**From:** Raymond <ray@circuli.com>  
**To:** <alan.cadogan@planning.nsw.gov.au>  
**Date:** 26/04/2013 6:56 PM  
**Subject:** Submission to MP 09\_0066 MOD 6 proposal - Thomas Street Carpark, Chatswood (Part3AMod)

I represent the owner of the block of 12 residential apartments at 4-6 Ellis Street, Chatswood. We would like to lodge an objection to Meriton's Mod-6 proposal for the Thomas Street carpark site currently under consideration in the Department of Planning. Below are the key points of our objection:

BUILDING 1
ELEVATION - EAST
A-0123
D
SECTION 75 W MODIFICATION 6

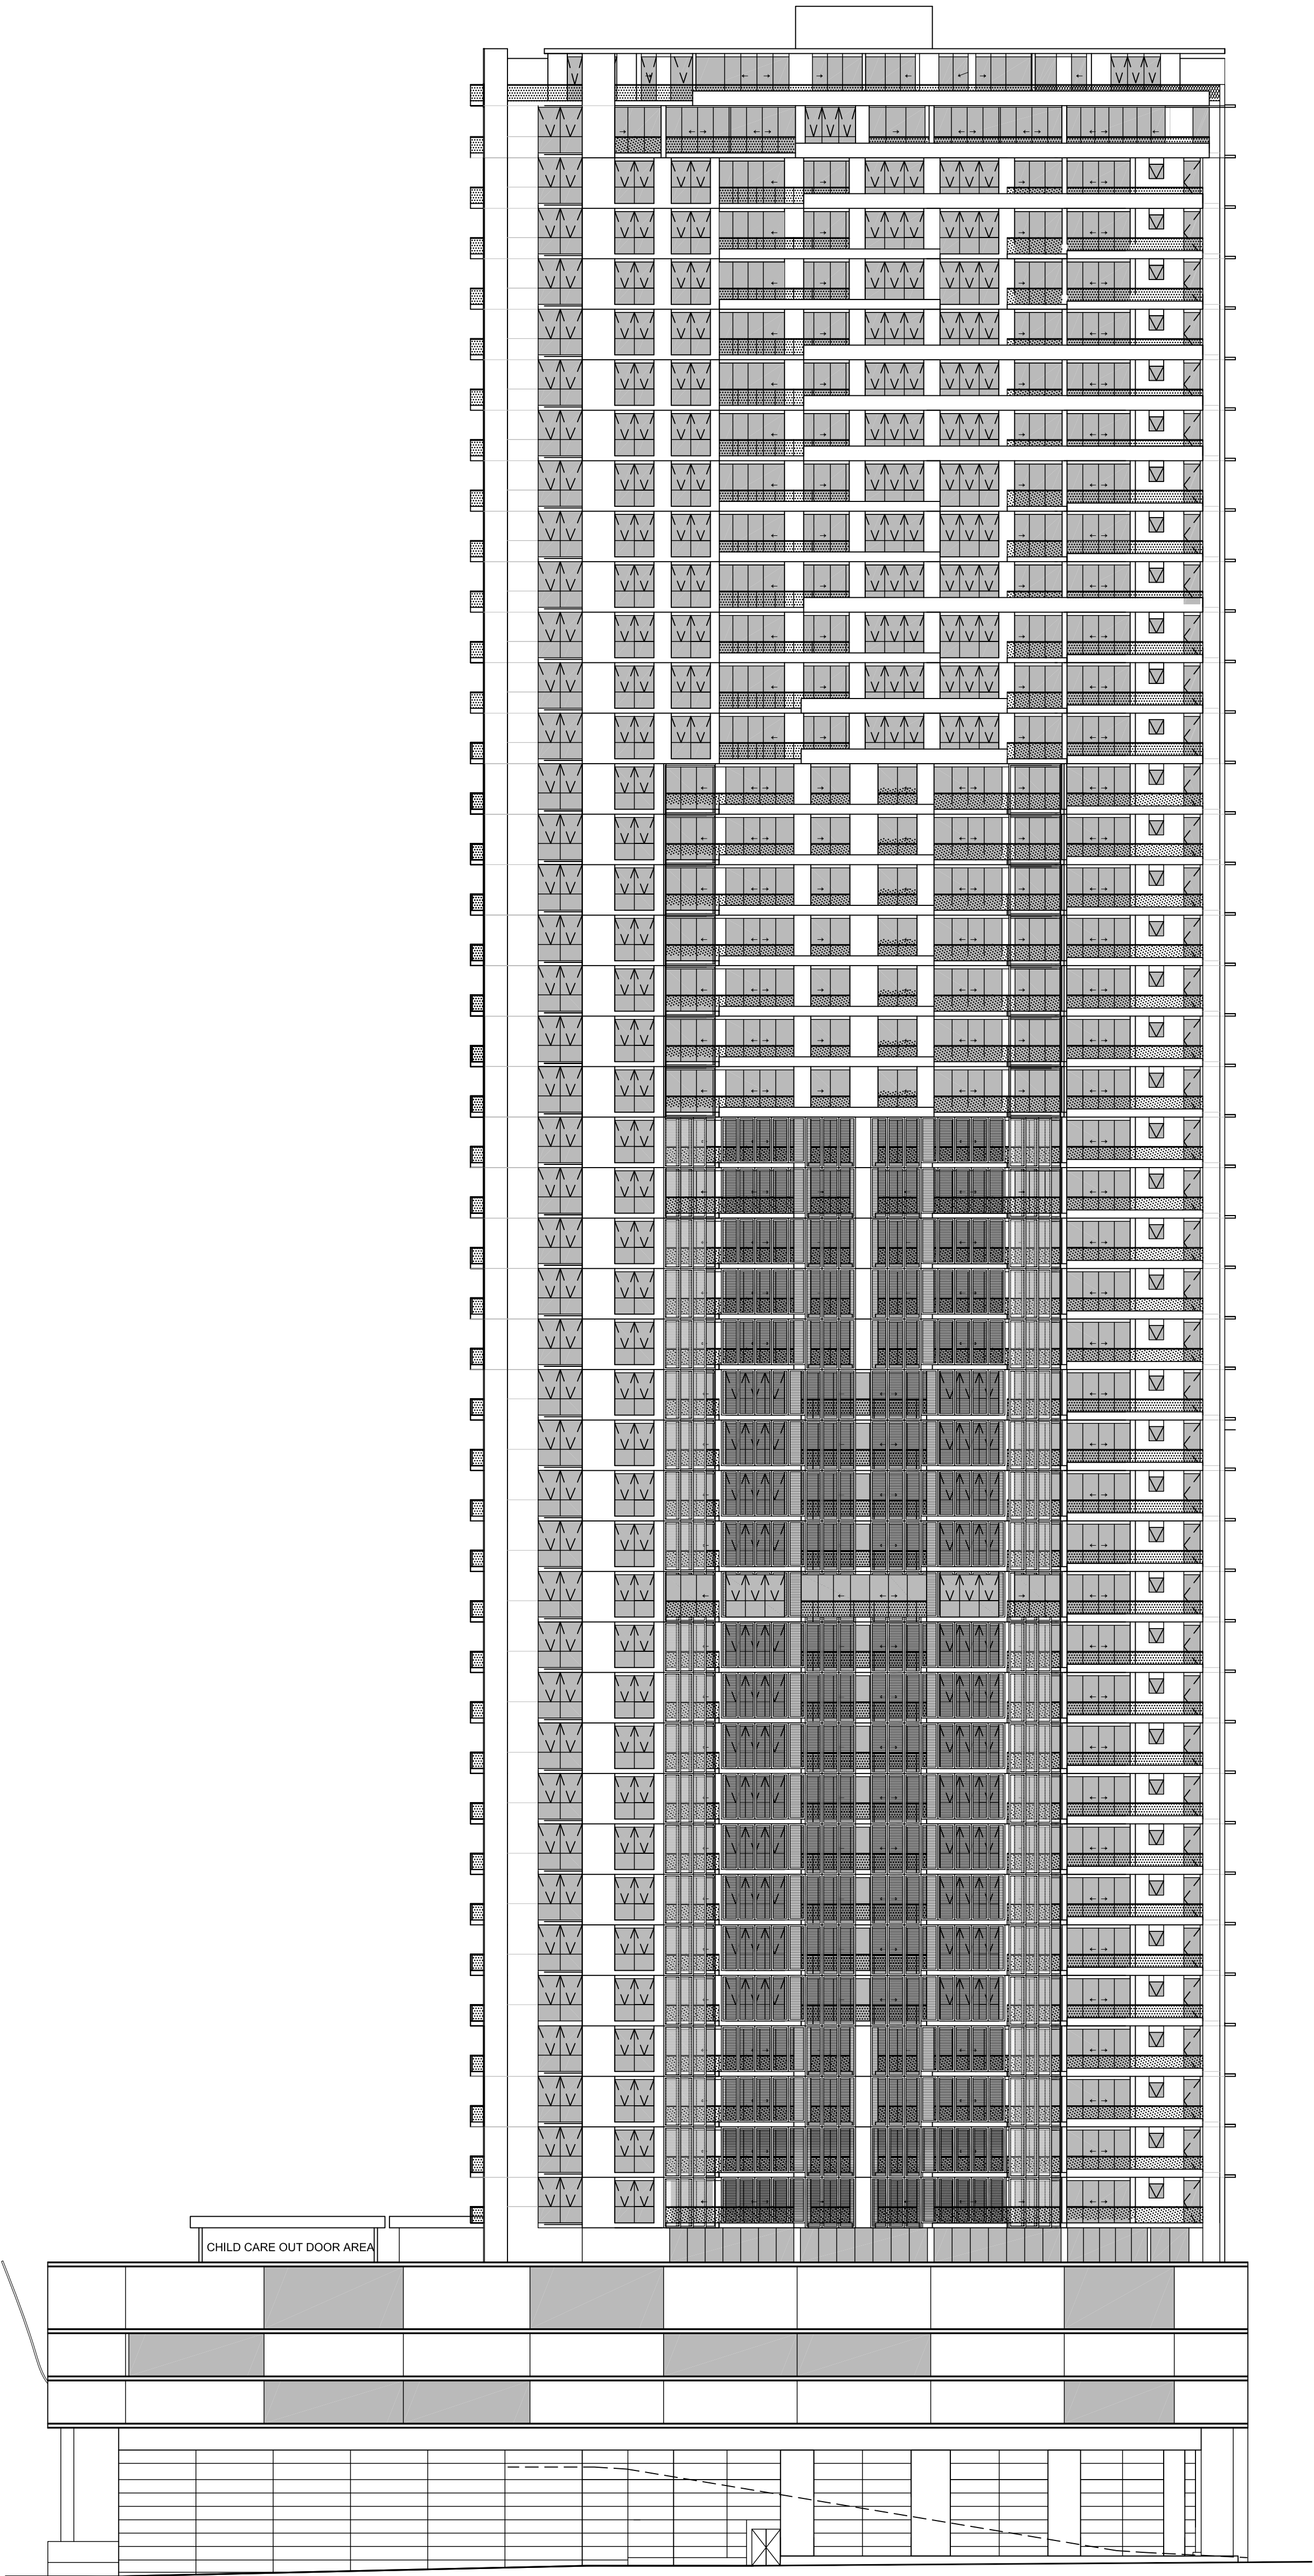
- Shadowing - The significantly increased height of both towers will produce overshadowing of our property within the time period from 12pm to 3pm for a greater proportion of the year than under the original approval.
- Increased traffic - Traffic generation is unacceptable given the surrounding road network already experiences significant congestion, particularly at the intersection of Crispe Lane and Albert Avenue.
- Scale - The proposal is on a vastly excessive scale for the site and is not in accordance with Willoughby Council's intention for development on the fringes of the Chatswood CBD, which "should be scaling down from the core to the 8 storey and 3-4 storey residential buildings to the south" (Willoughby Council - submission, 27 March 2013)
